**Mallard Pass Solar Farm. Closing Summary Statement by Dr Geoffrey Radley MCIEEM
(Retired) OBE, Interested Party no. 20036053**

In the course of the examination process, the Applicants have at least partially addressed some these areas of concern, but have not addressed others. From the latest available version of the Outline Landscape and Environmental Management Plan (Revision 5, Document REP7 – 021) and the Outline Construction Traffic Management Plan (Revision 6, Document REP7 -024) the current position appears to be as follows:

Proposed Wildflower Grassland with Calcareous Species adjacent to LWS and SSSI - Biodiversity enhancement.

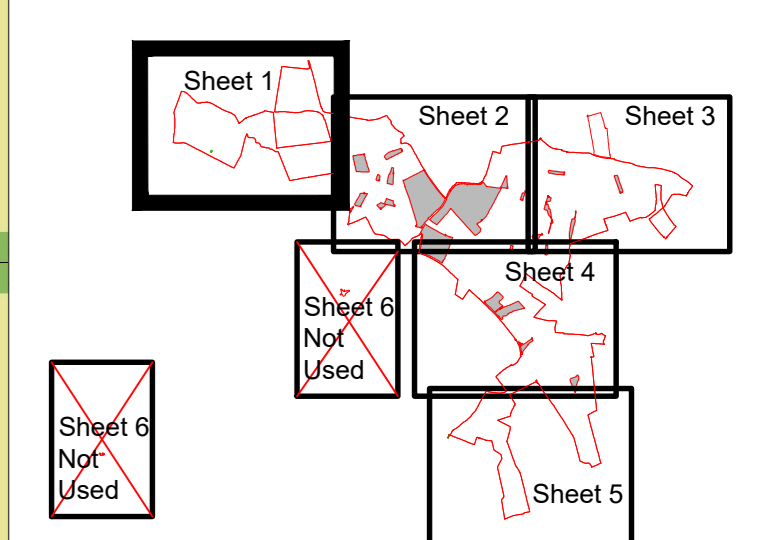
Section 4.2.27 of the latest version of the Outline Landscape and Environmental Management Plan still states that Fields 1 and 3, where it is proposed to establish wildflower grassland with calcareous species, will be cut every two years on rotation in late summer. This is despite myself and other Interested Parties pointing out that this cutting regime is completely inadequate if the aim is to maintain a diverse sward. On productive ex-arable soils, which typically have high levels of phosphate, newly

established grass swards need to be cut much more frequently to prevent a small number of fast-growing, competitive plants outcompeting and eliminating the rest of the sown species.

3. A requirement to cut the newly established areas of wildflower grassland with calcareous species sufficiently frequently to allow the establishment of the full range of sown species. Note that this will require the removal of all cut vegetation.
